**Our Case Number:** ABP-317660-23

**Re:** Busconnects Kimmage to city centre core bus corridor scheme  
Kimmage, Dublin

## Kimimage to City Centre Core Bus Corridor Scheme

Submission to An Bord Pleanála on behalf of Mount Jerome Cemetery and Crematorium, Harolds Cross, Dublin 6

Programme Title BUSCONNECTS DUBLIN CORE BUS CORRIDORS INFRASTRUCTURE WORKS			
Drawing Title KIMMAGE TO CITY CENTRE CORE BUS CORRIDOR SCHEME GENERAL ARRANGEMENT			
Drawing File Name BCIDD-ROT-GEO_GA-0011_XX_00-DR-CR-0001	Sheet Number 01 of 14	Status A	Rev M01

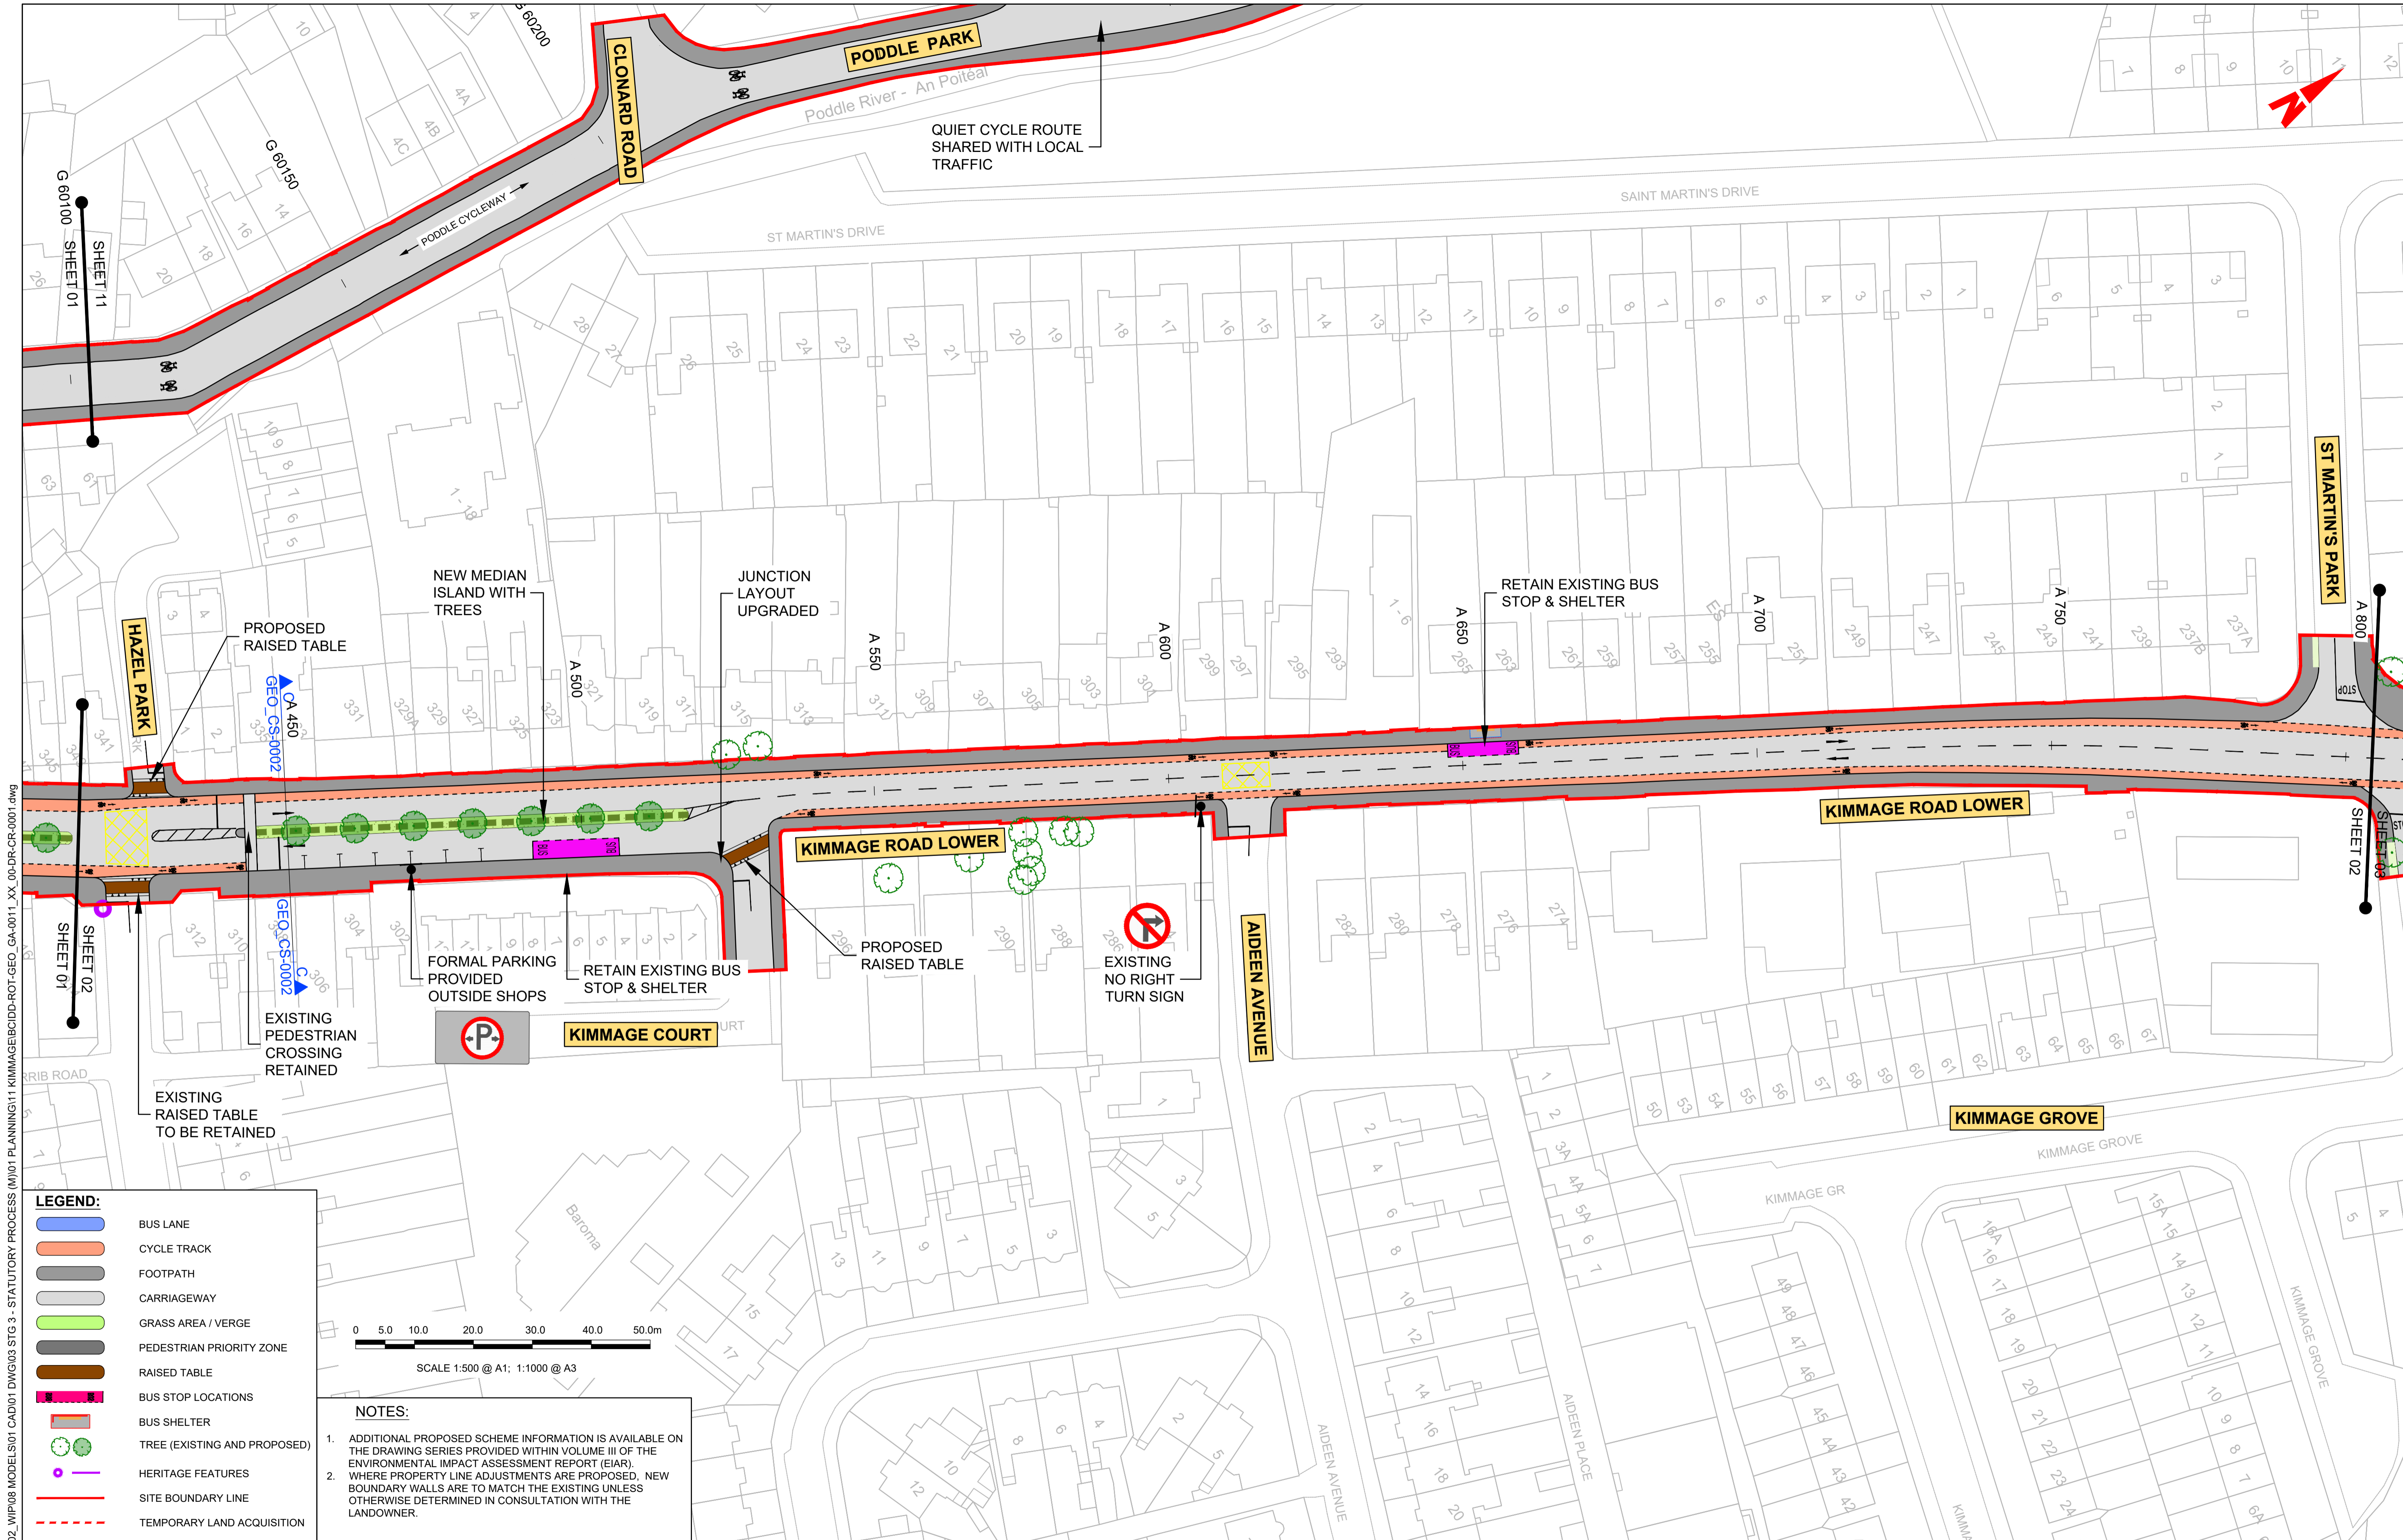
Figure 8 Bus Gate at Kimmage Road Lower, just north of the Ravensdale Park Junction.

(Extract from General Arrangement Drawing No 1)

The first of these is proposed to be located on Kimmage Road Lower to the north of the junction with Ravensdale Park with operational hours of 6am – 10am and 4pm to 8pm.

Drawing File Name: BCIDD-ROT-GEO_GA-0011_XX_00-DR-CR-0007
Sheet Number: 07 of 14
Status: A
Rev: M01

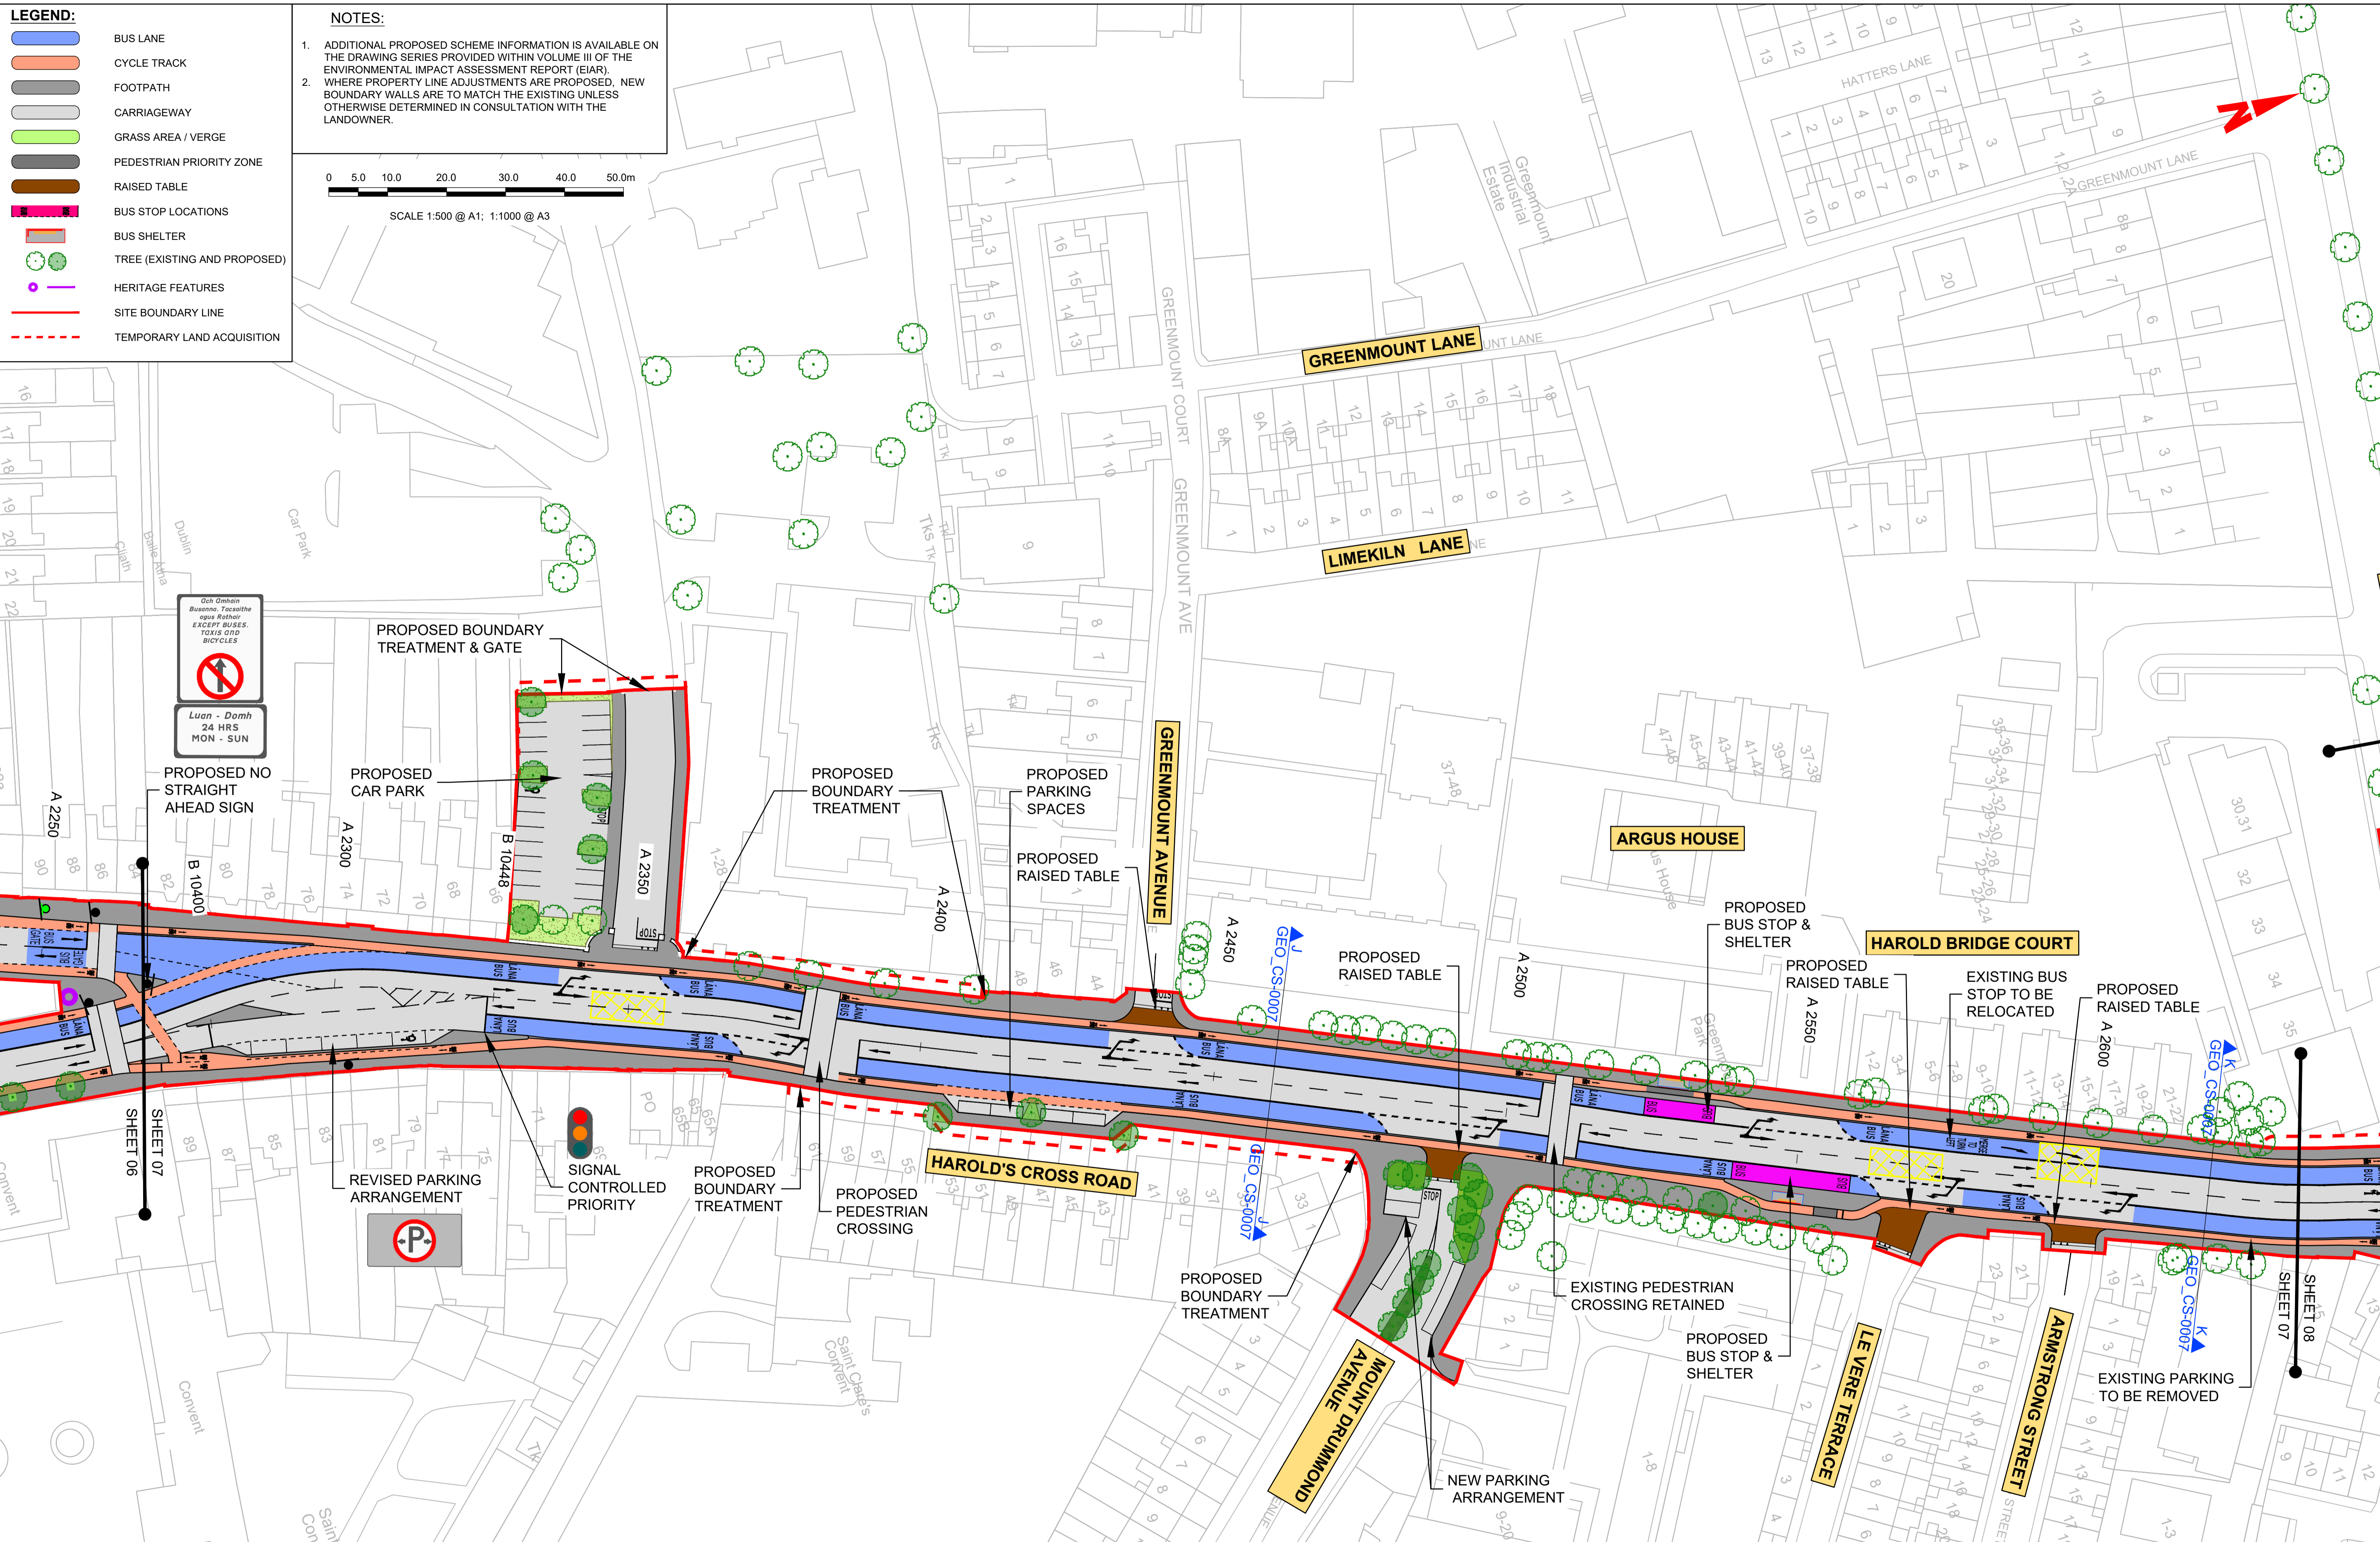
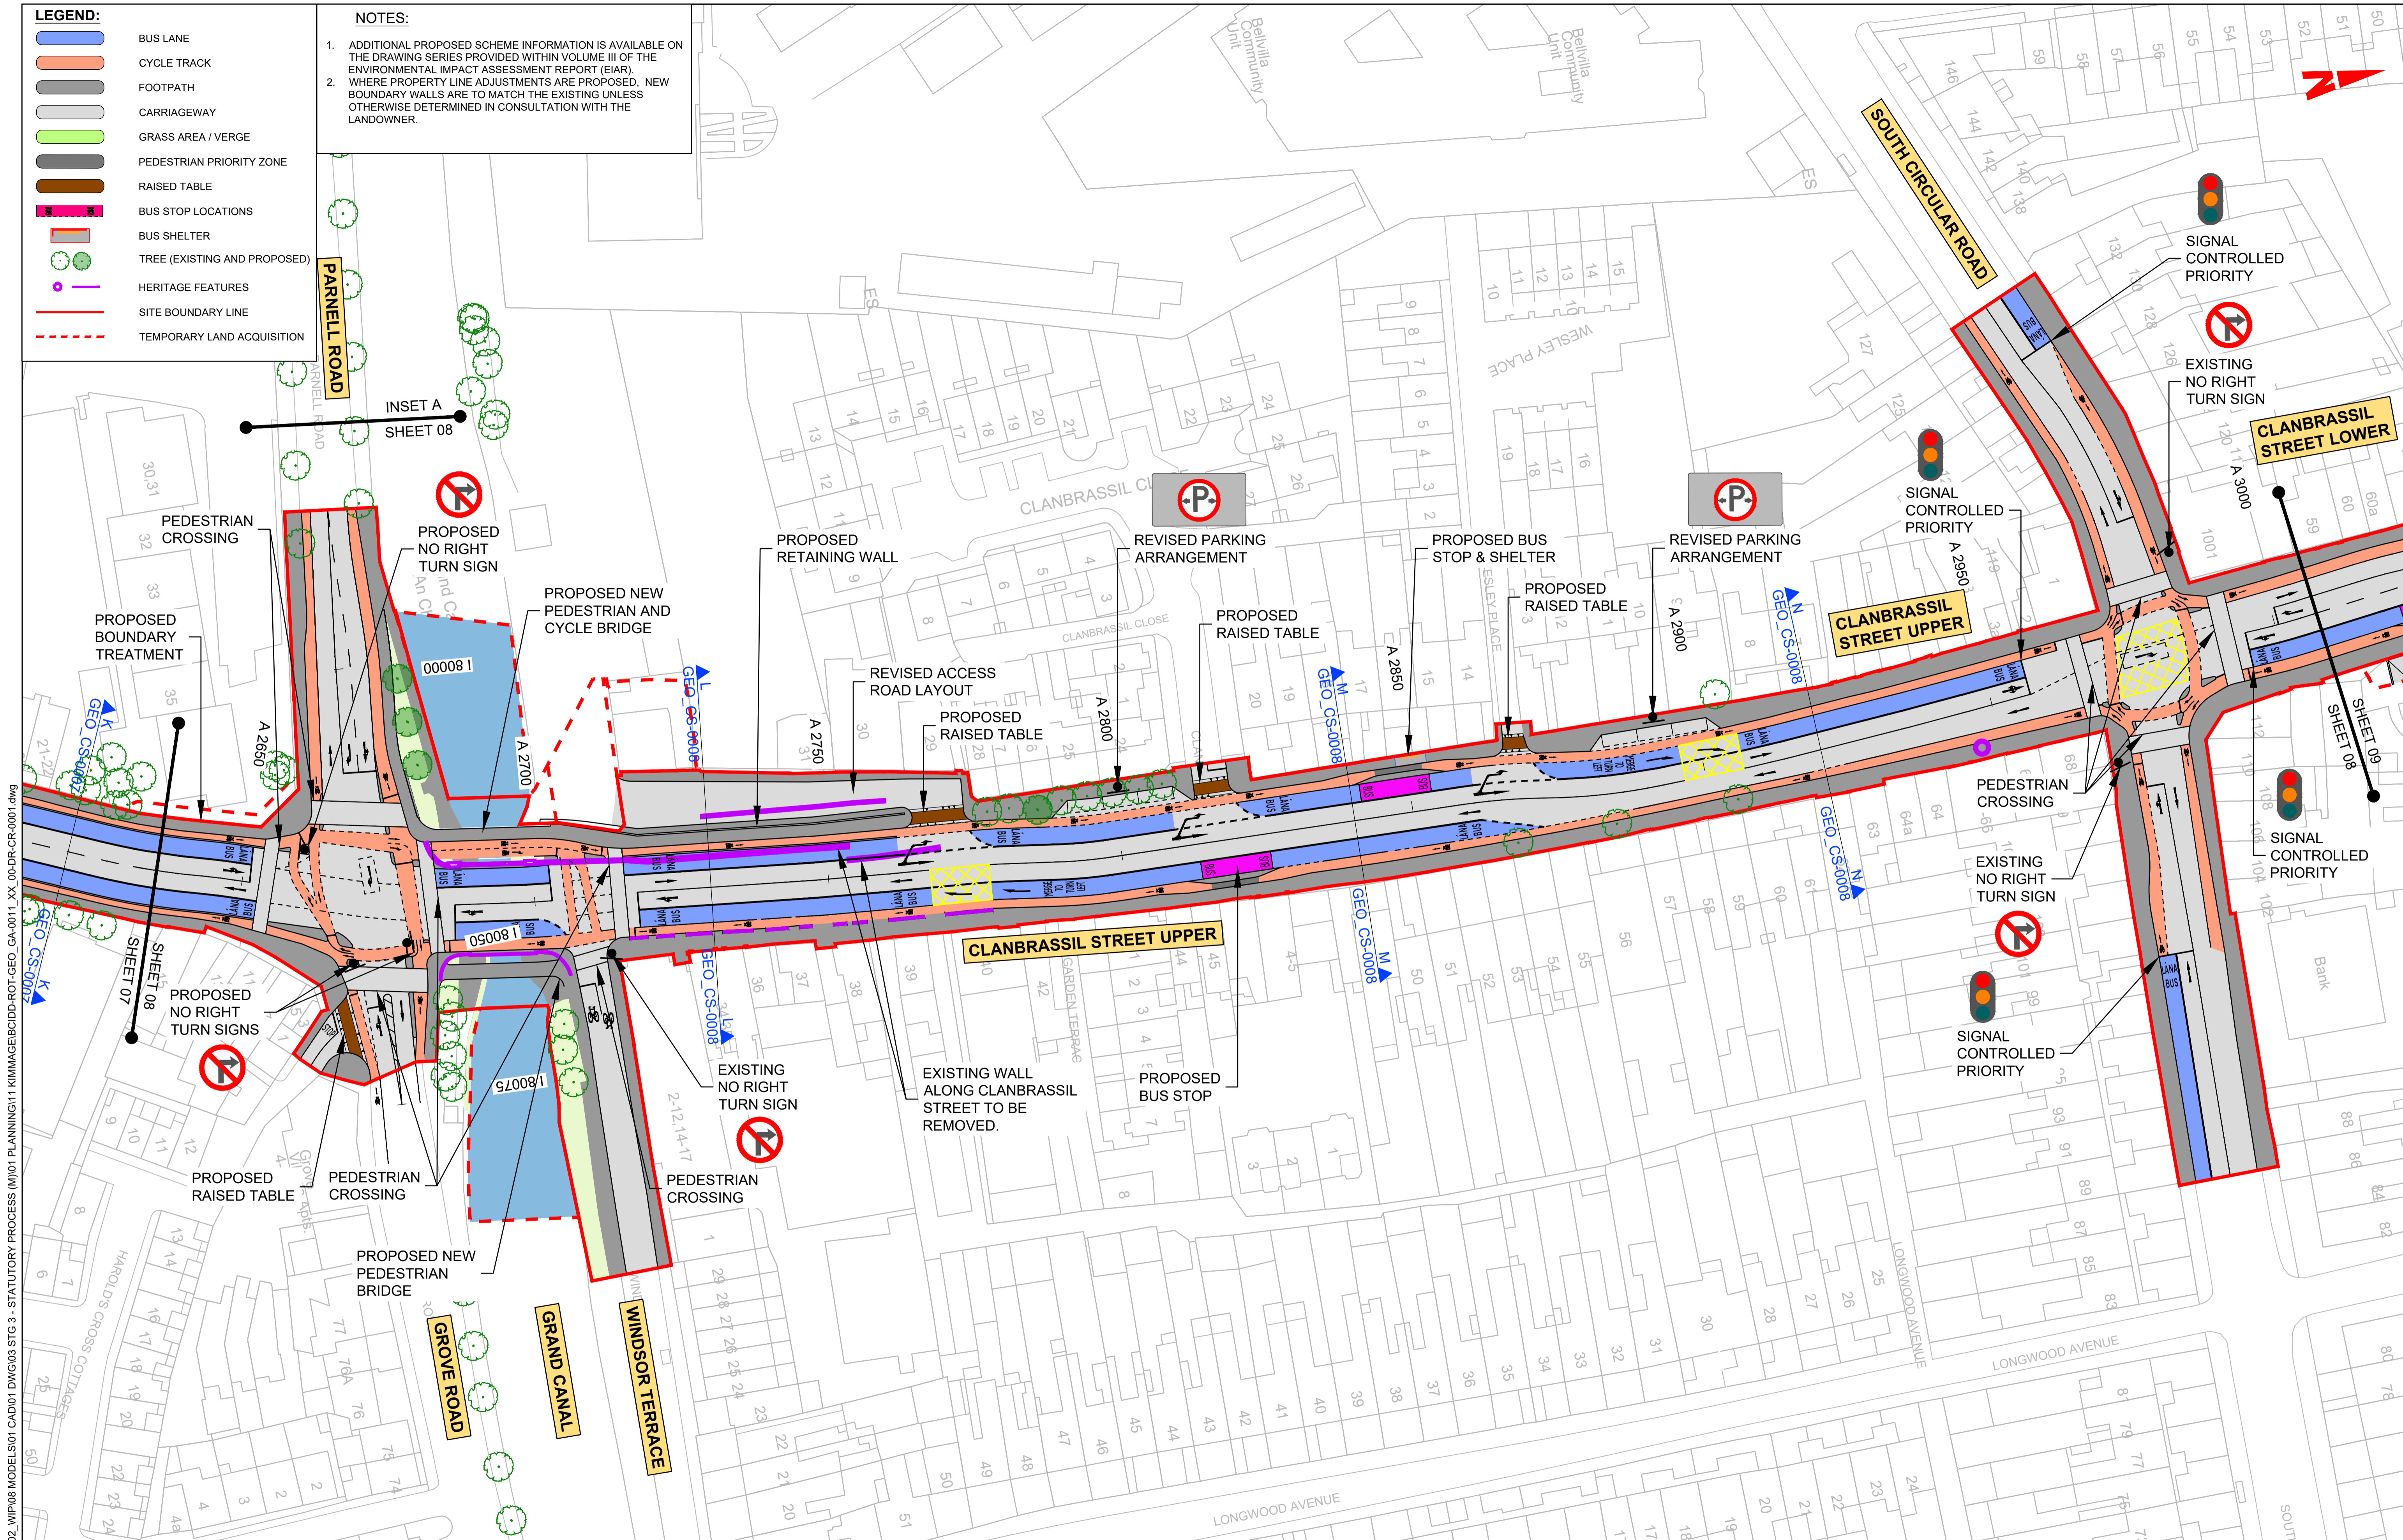
The proposed bus gate at the northern end of Harolds Cross Park also includes a no left turn for traffic exiting Mount Jerome onto Harolds Cross Road See Figure 9.

Figure 9 Bus Gate at Kimmage Road Lower, just south of Harolds Cross Park  
 (Extract from General Arrangement Drawings No 5 and 6)

Figure 10 Bus Gate at Harolds Cross Road , at the northern end of Harolds Cross Park  
(Extract from General Arrangement Drawings No 6 and 7)

The second is proposed to be located where the Kimmage Road Lower joins the Harold's Cross Road just to the south of the entrance to Mount Jerome. This bus gate would have operational hours of 24 hours in both directions.

The third is proposed to be located on the Harold's Cross Road on the north side of the Harold's Cross Park just to the north of the entrance to Mount Jerome. This bus gate would have operational hours of 24 hours (southbound) and 6am to 10am (northbound).
